Reference: 190509.01FC

### LETTER OF ADVICE OF PROPOSED RESOURCE RECOVERY FACILITY AT 7 MONTORE ROAD, MINTO

Reference is made to your request to provide Letter of Advice for the Proposed Resource Recovery Facility at 7 Montore Road, Minto (Concept Site layout in **Annexure A**). This letter addresses comments from the Department of Planning in reference to *M<sup>C</sup>Laren Traffic Engineering's (MTE) Traffic and Parking Impact Assessment (TPIA)* dated 5<sup>th</sup> February 2019 (ref 18259.01FB). The Department comments are quoted below followed by **MTE's** responses.

EXITING SITE

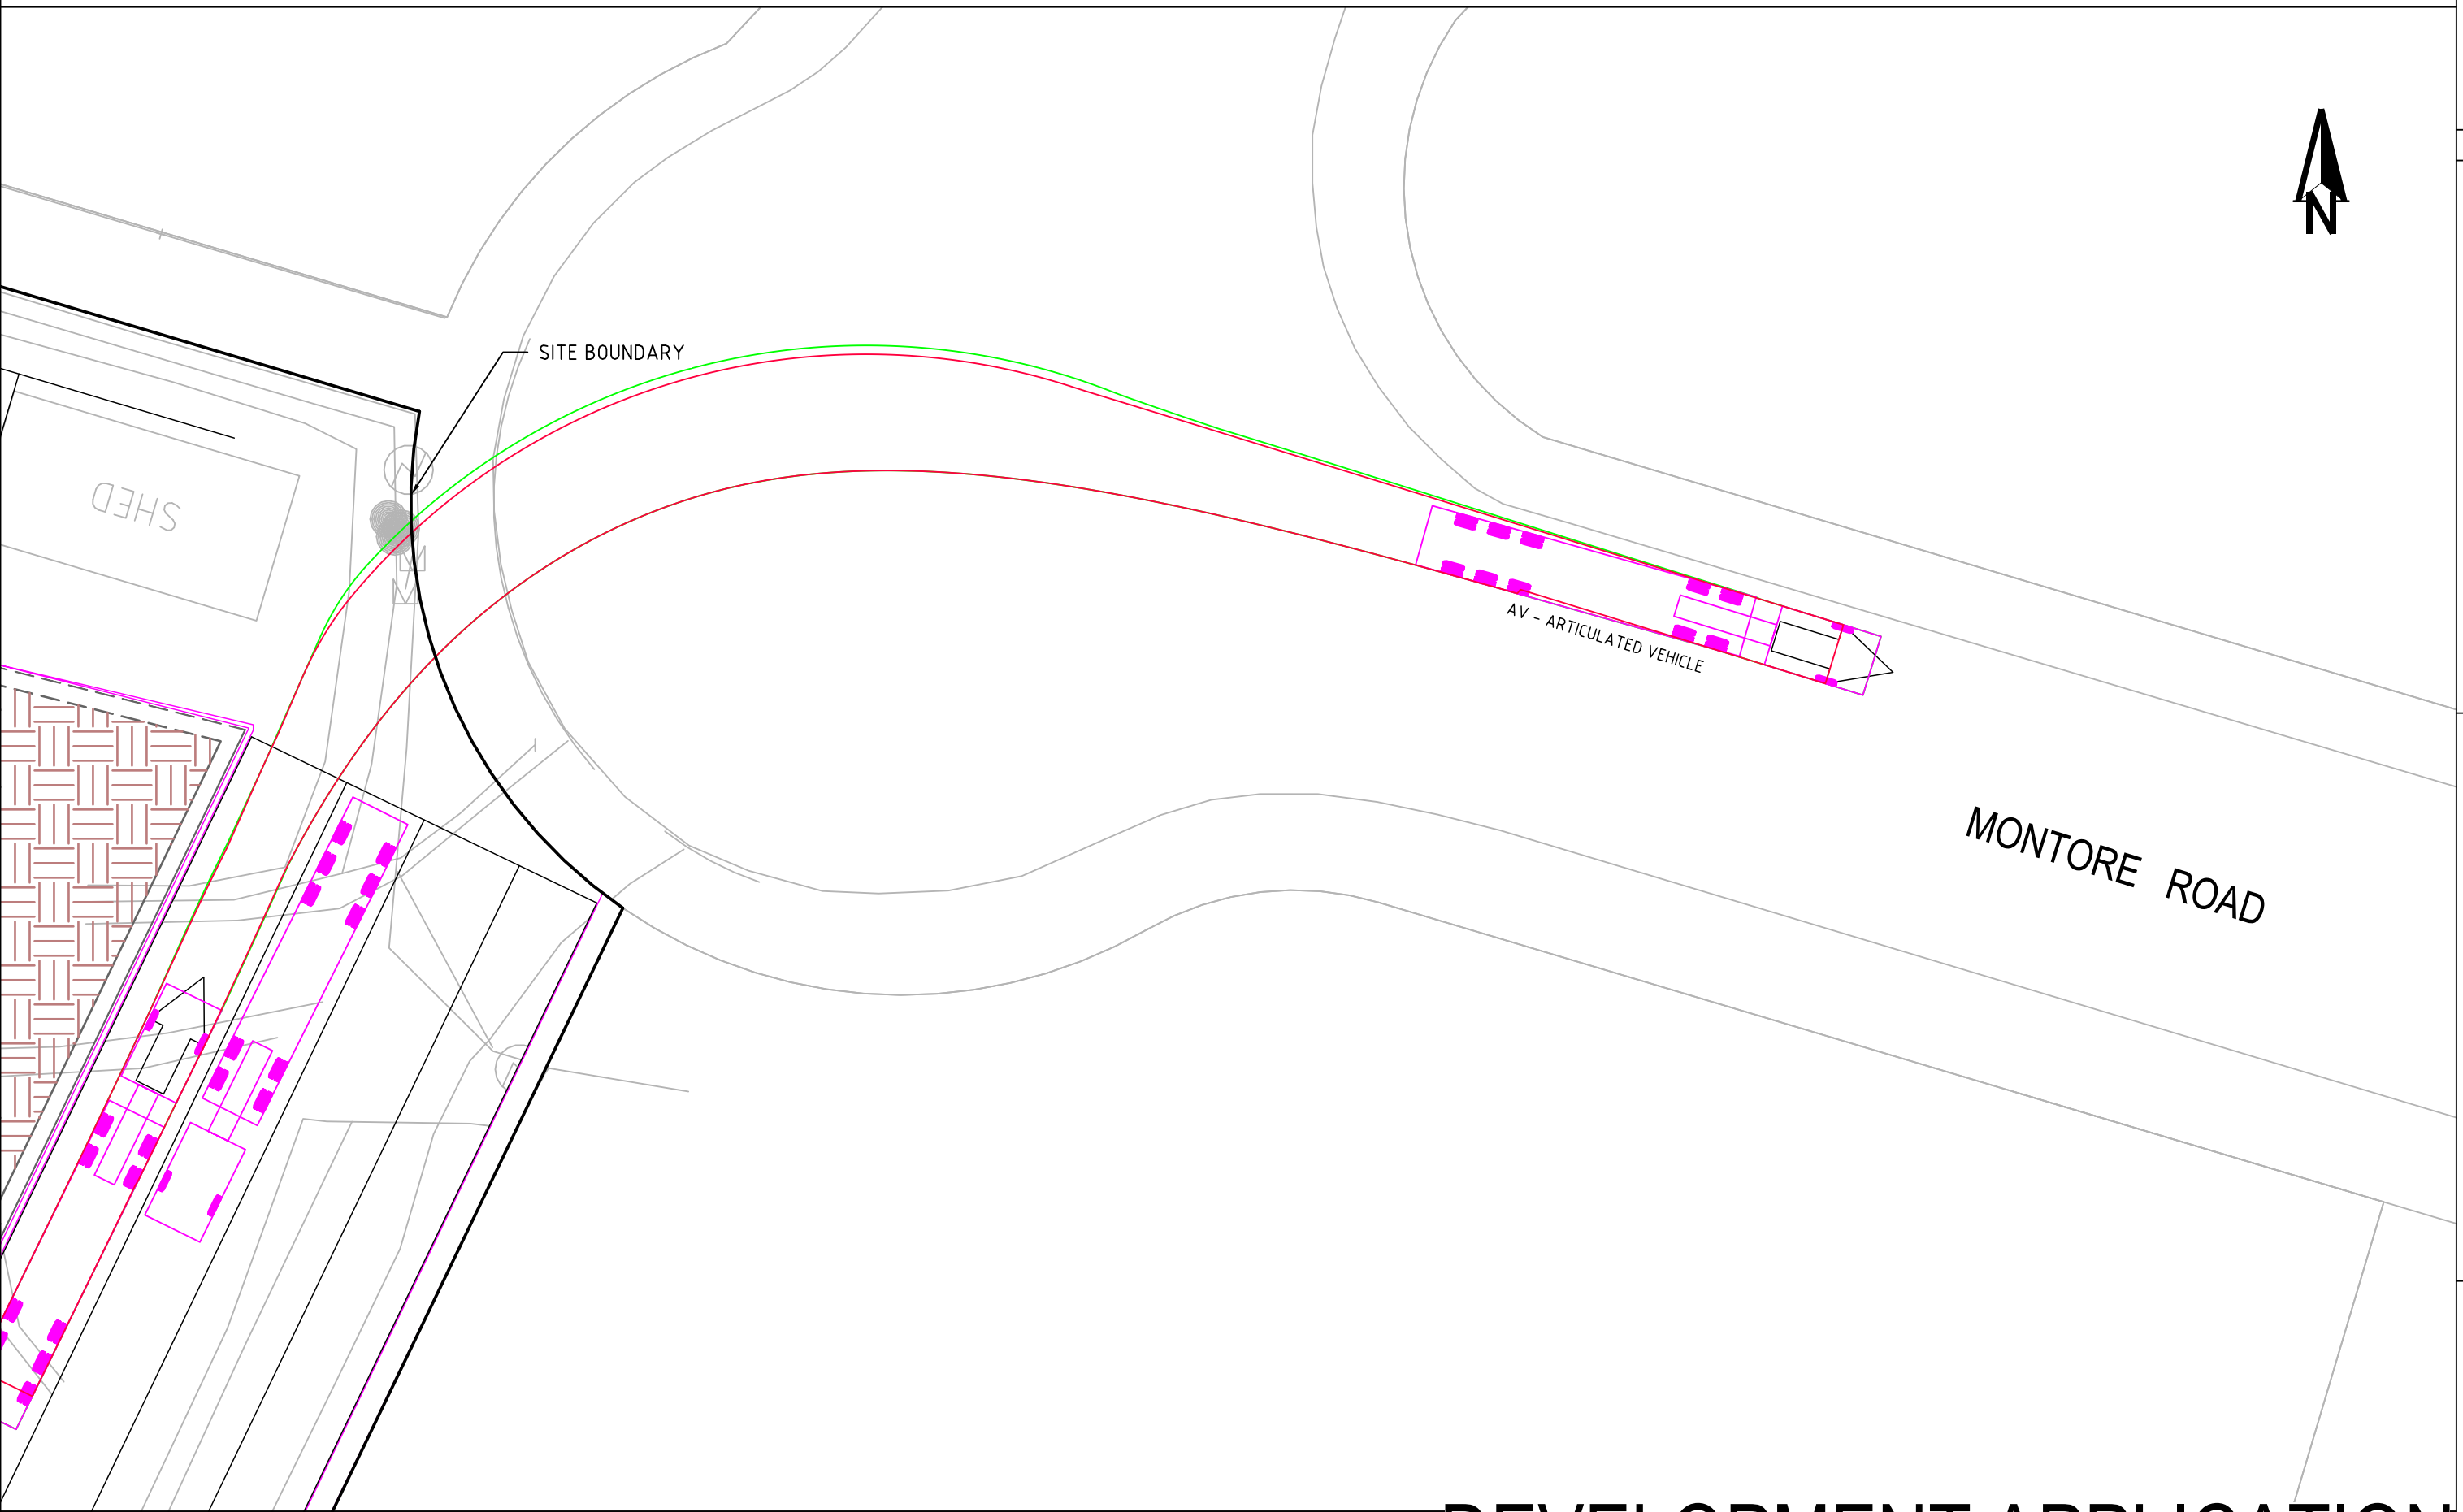
*Describe the site access, will it be upgraded?*

**MTE Response:** The site access is shown in the plans in **Annexure A**. The proposal requires a significantly wider layback than what is provided on the existing site. The singular layback will provide access and egress to both the weighbridge for AV's and the car park for passenger vehicles. The existing and proposed laybacks are compared in **Figure 1** and **Figure 2** below. Additionally, the original TPIA, dated 5<sup>th</sup> February 2019, has been updated to include these figures.
